Arun District Council
Arun Civic Centre
Maltravers Road
Littlehampton
West Sussex BN17 5LF
Planning & Building Control General Enquiries
Tel: (01903) 737756 Fax: (01903) 730442
Dx: 57406 Littlehampton
Minicom: 01903 732765
e-mail: planning@arun.gov.uk
website: www.arun.gov.uk/planning

Application No: FP/212/20/OUT
Site Address: Pipers Croft 6 The Loop Felpham PO22 7ND
Description of works: Outline application with all matters reserved for 1 No. 4 bed detached dwelling.

Thank you for your internet representation made on 1st December 2020 which has been recorded as an objection with the comments as follows:

Block Plan

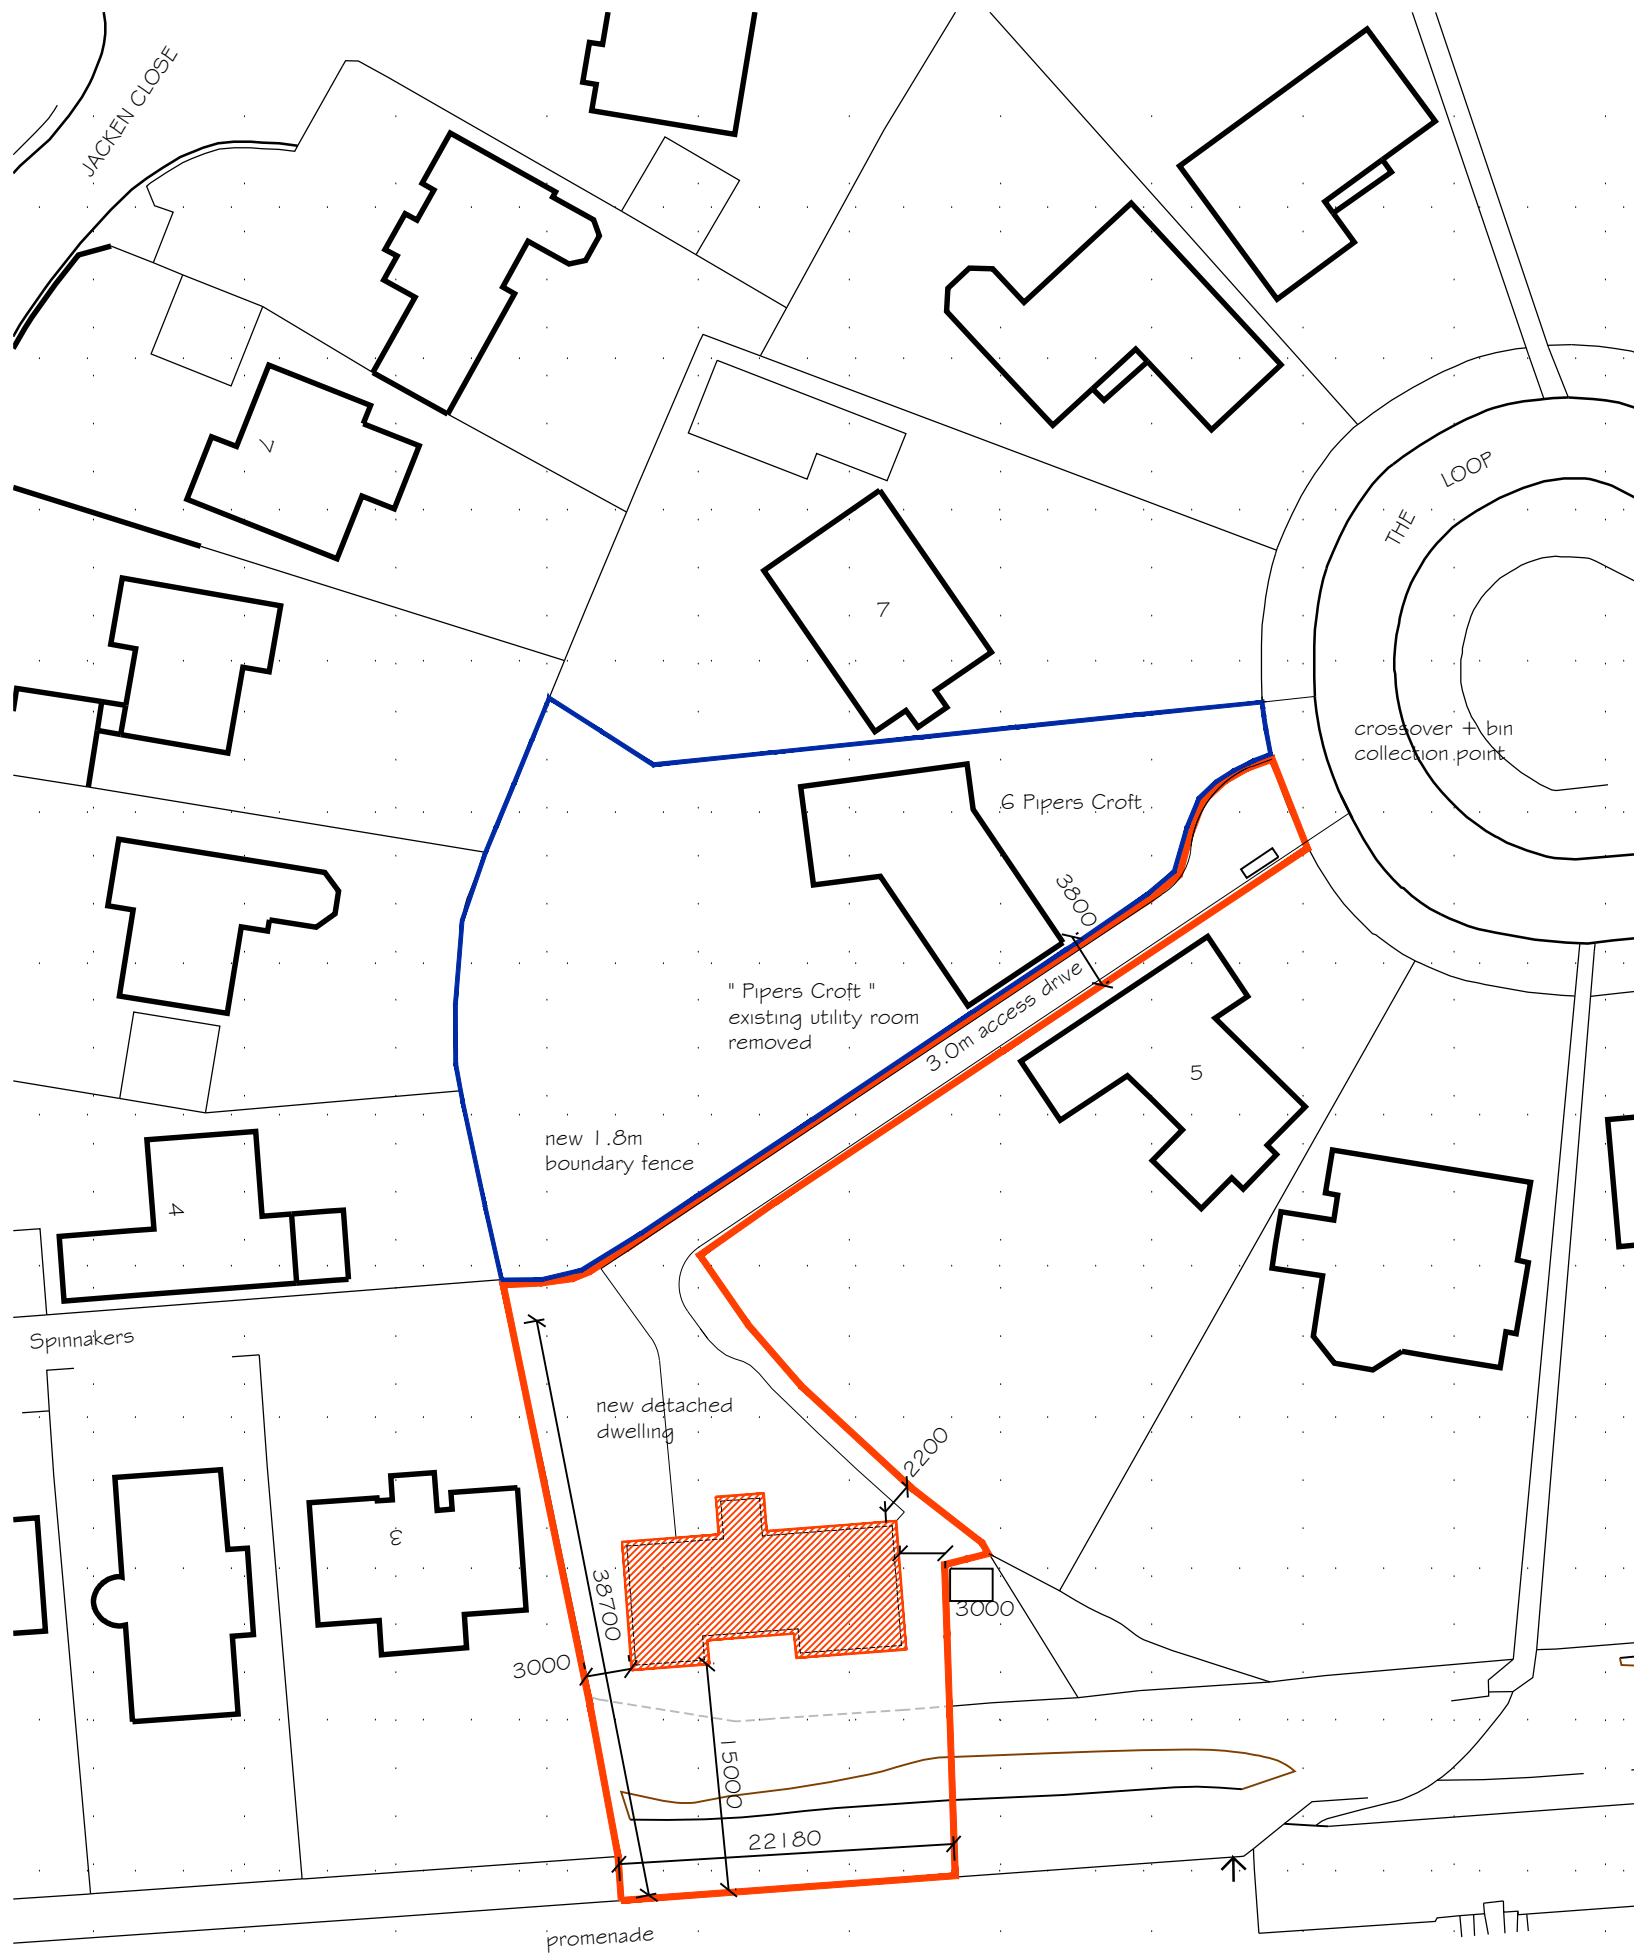
1. The proposal builds on top of a pond which will increase flooding likelihood.
 2. Trees have recently been removed (without care for resident birds and bats) which will exacerbate flooding.
 3. The drawings are misleading. The house, as proposed, will butt up to the existing fence.
- For the above reasons I object to the application.
